**Development Review Board (DRB)
Review Comments
Utility Development Section
Reviewer: Kristopher Cadena, P.E.
Phone: 505.289.3301**

DRB Project No: 1004428	Date: 05/09/18	Item No: #5
Zone Atlas Page: P-9	Legal Description: Tract(s) RR-3-A, RR-3-B, RR-3-C, RR-3-D, AND RR-3-E, CEJA VISTA Location: on DENNIS CHAVEZ BLVD SW south of 98 th ST SW and UNINCORPORATED AREAS	
Request For: 18DRB-70007 - AMENDMENT TO PRELIMINARY PLAT

AMENDED PRELIMINARY PLAT FOR
CEJA VISTA SUBDIVISION
UNITS 1 A, 1 B, 1 C, 2 AND 3
 WITHIN THE
TOWN OF ATRISCO GRANT
 PROJECTED SECTION 9
 TOWNSHIP 9 NORTH, RANGE 2 EAST, NMPM
 CITY OF ALBUQUERQUE
 BERNALILLO COUNTY, NEW MEXICO
 DECEMBER, 2017

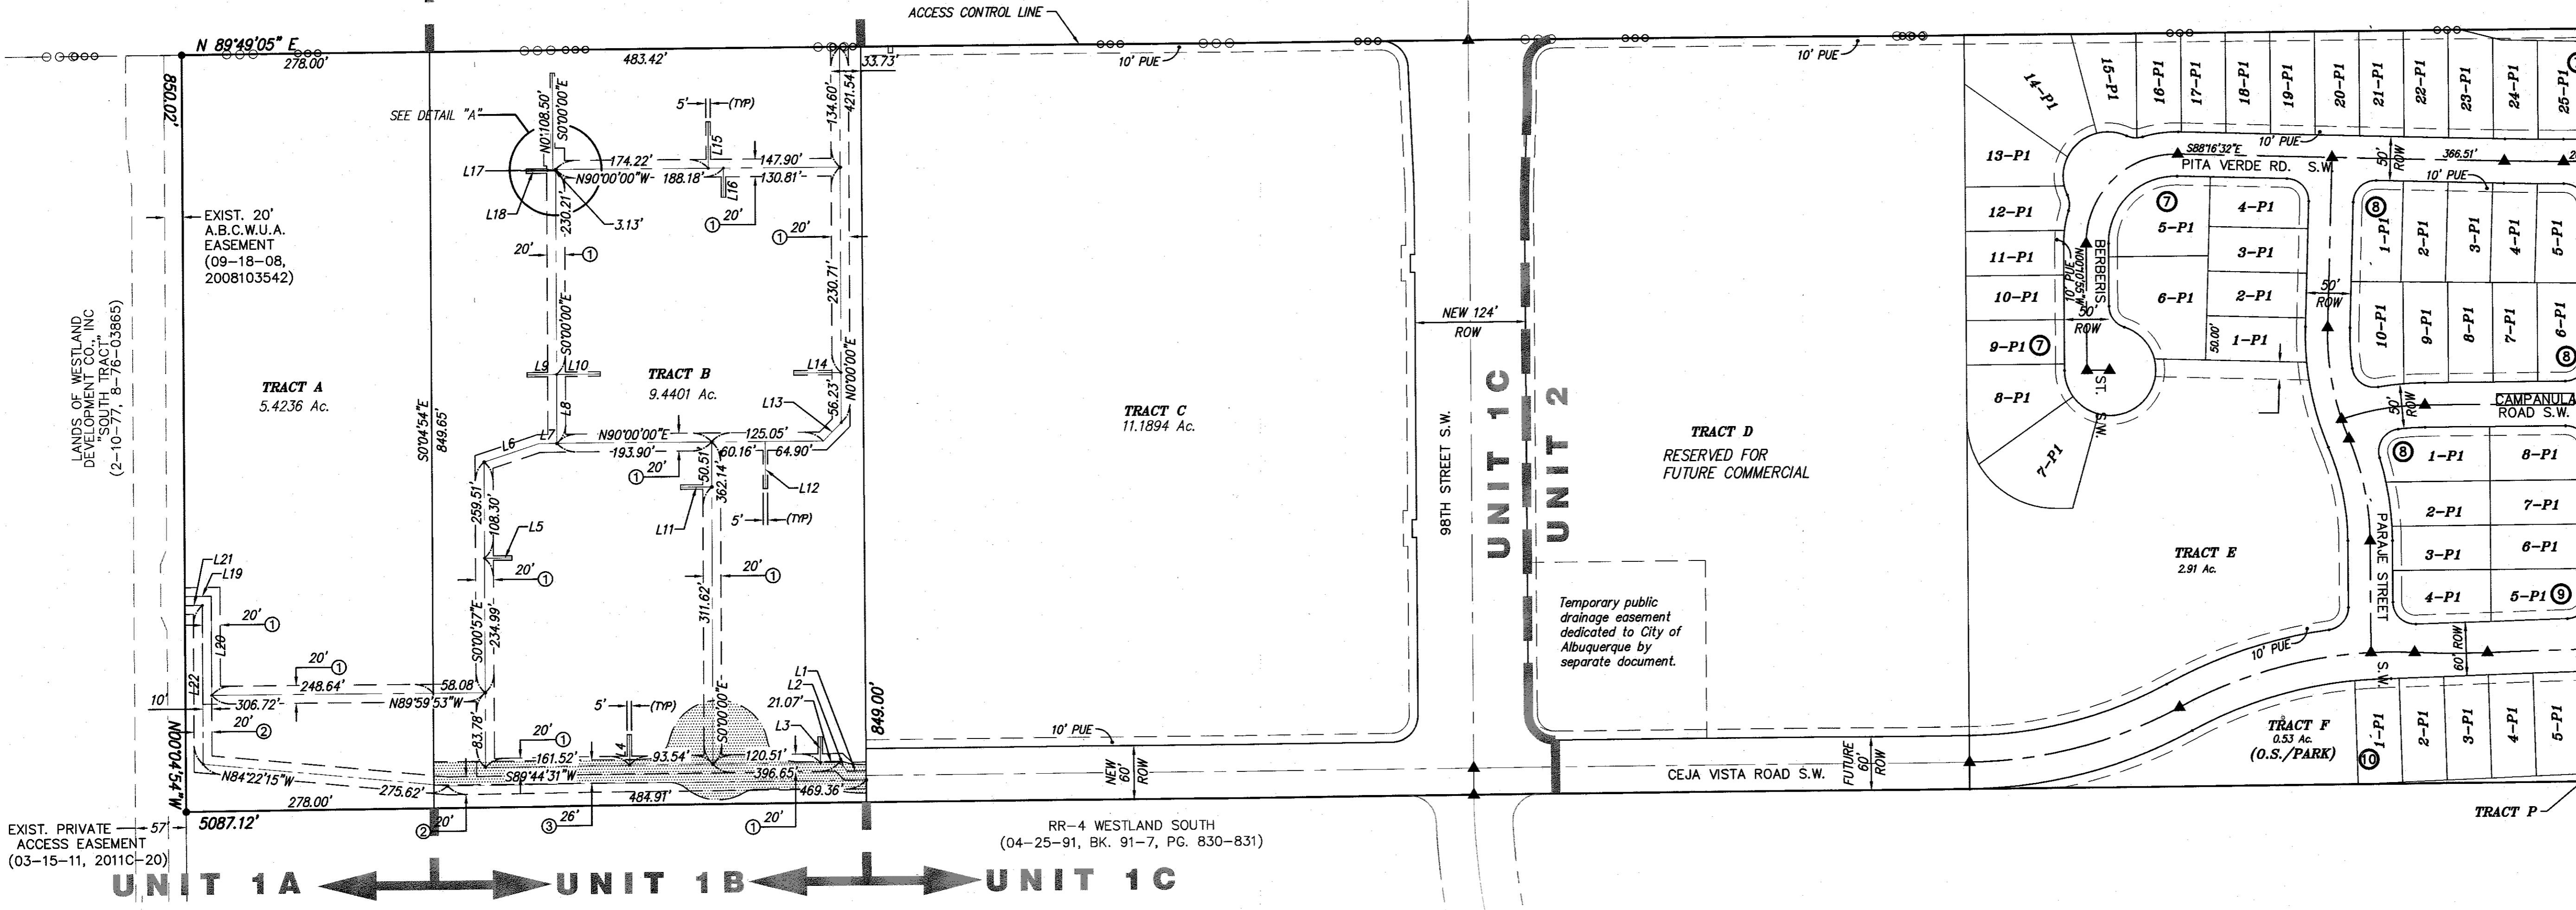
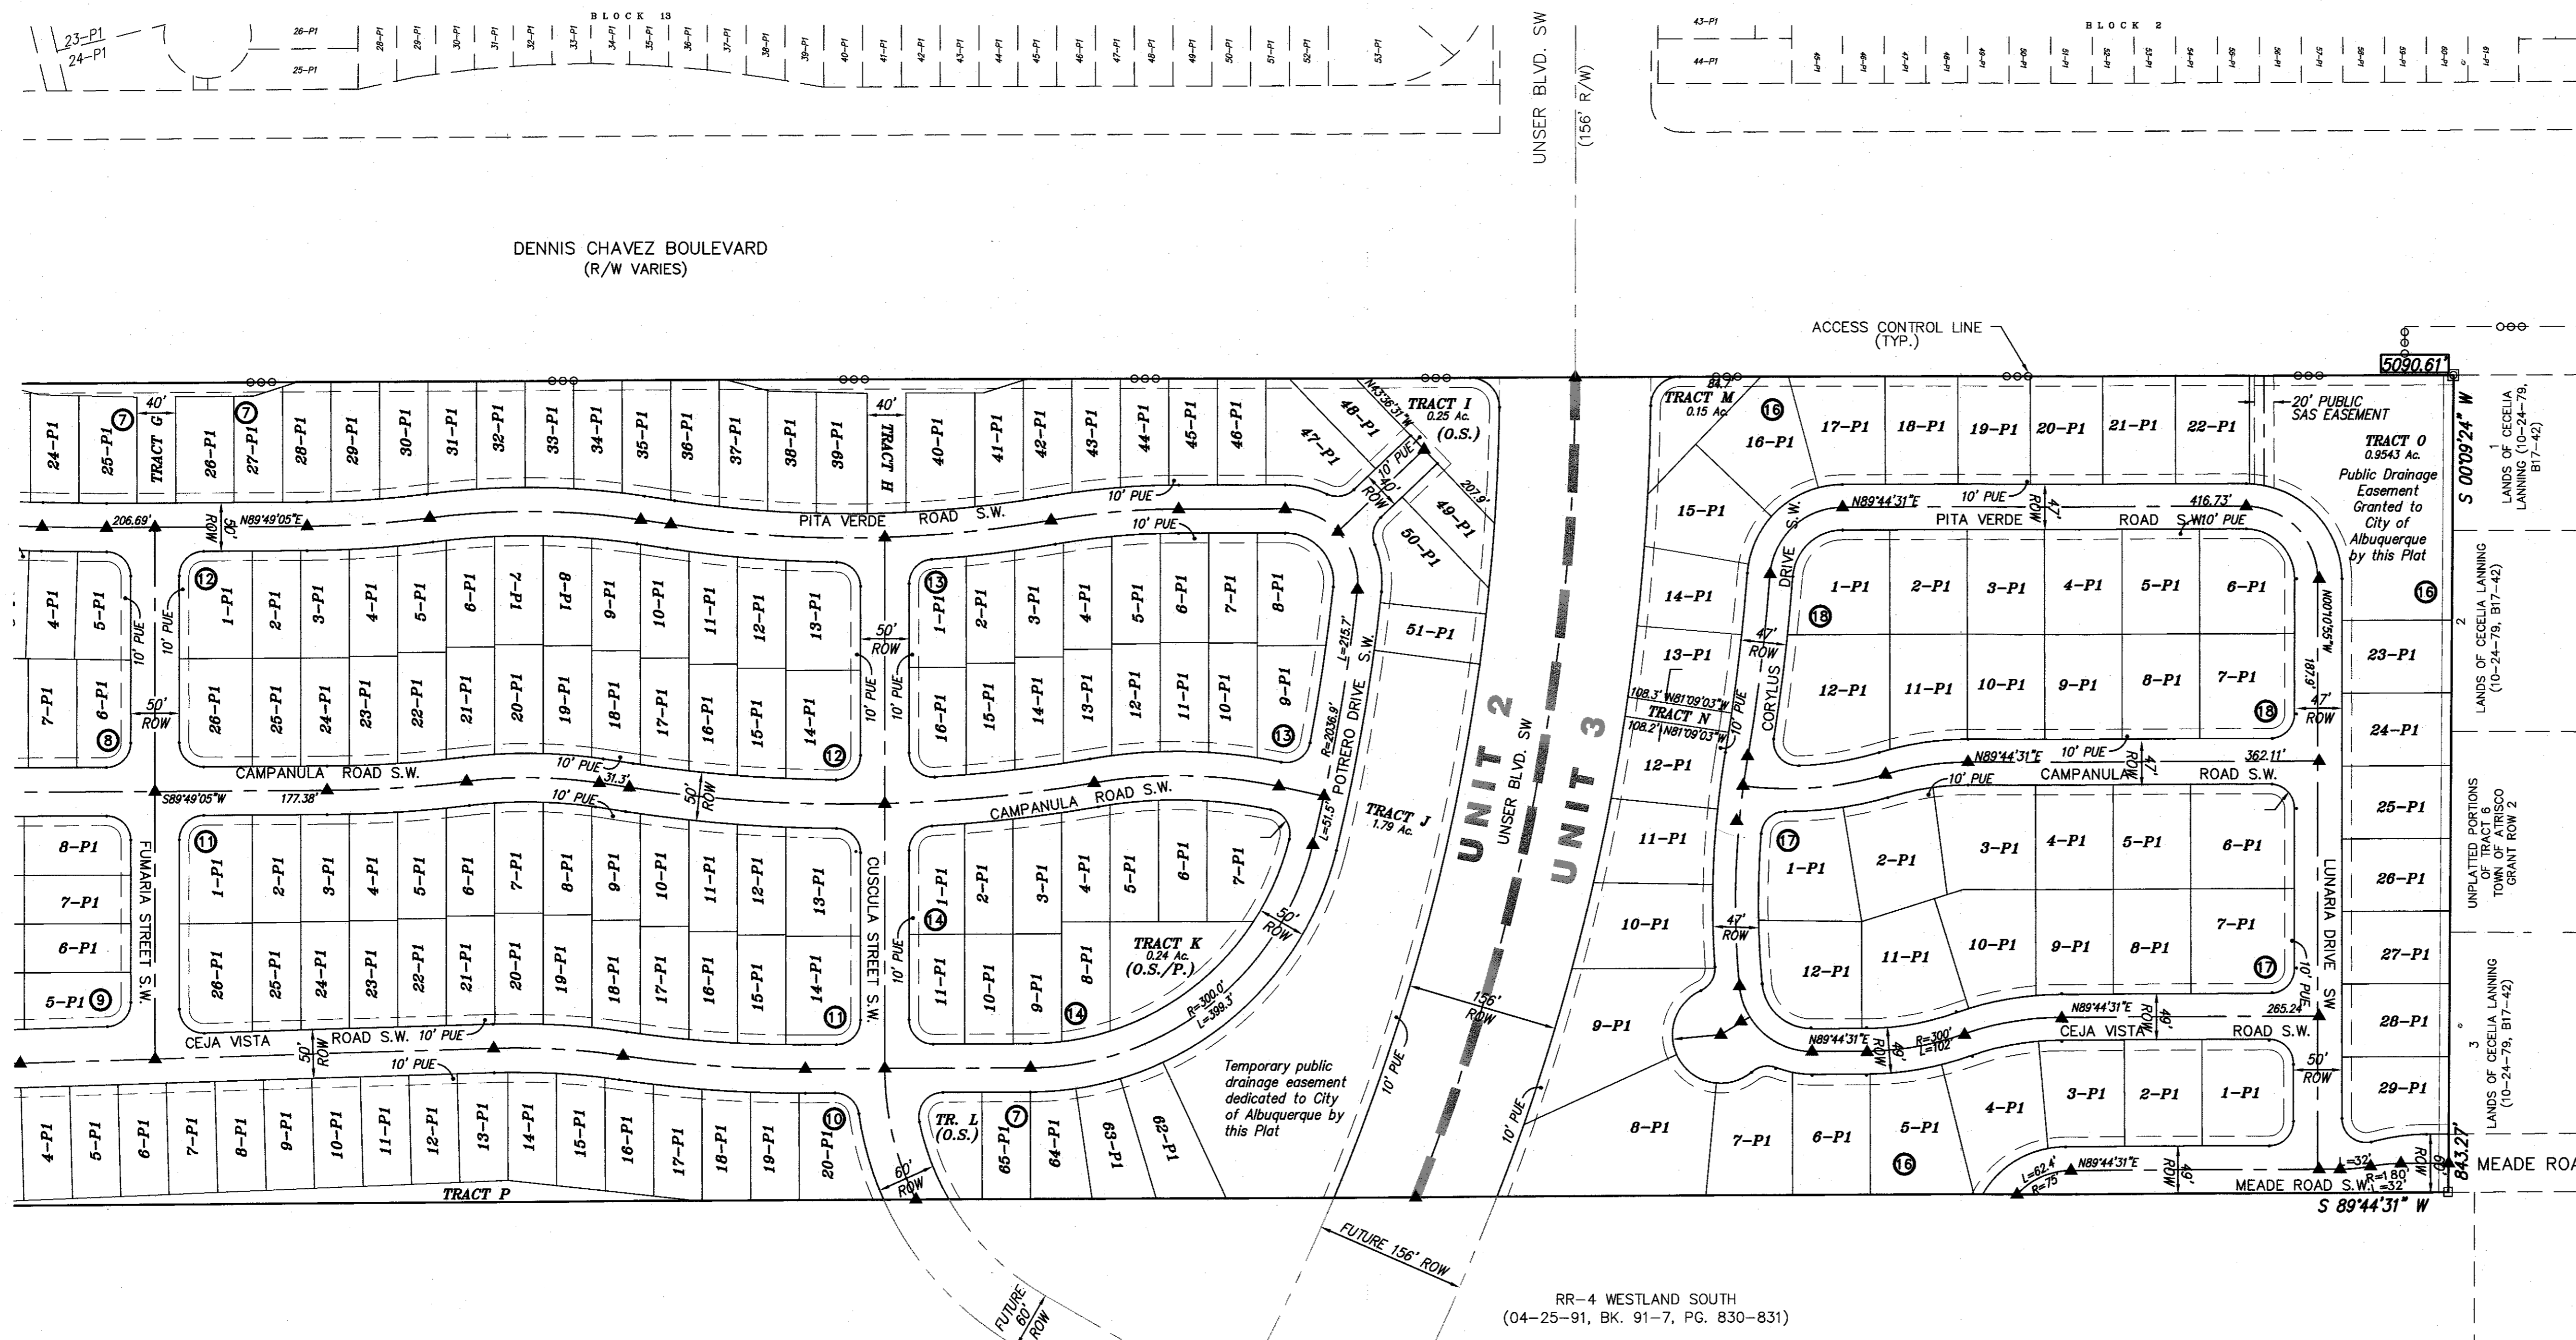
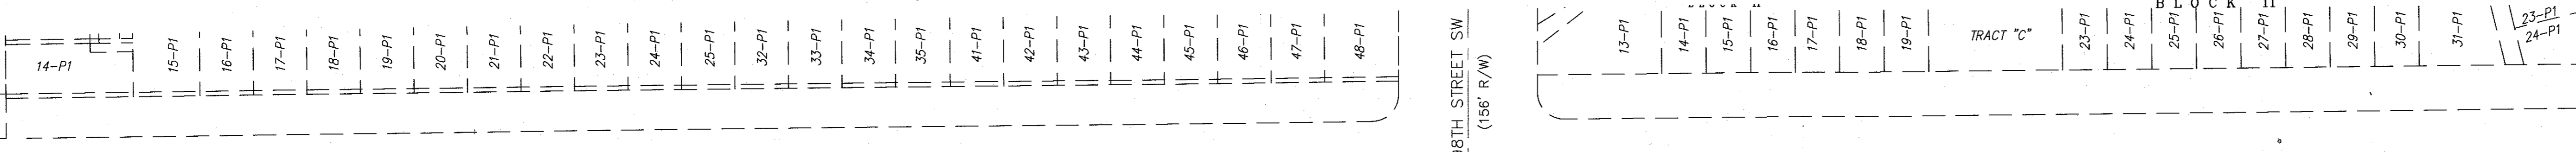
- a. Spoke with engineer on 5/8/18 to change the beginning point for the 8" reuse water line in Unit 1 to Dennis Chavez Blvd. instead of "Existing 12" WL (2WR)". If this change is made, there are no other objections.
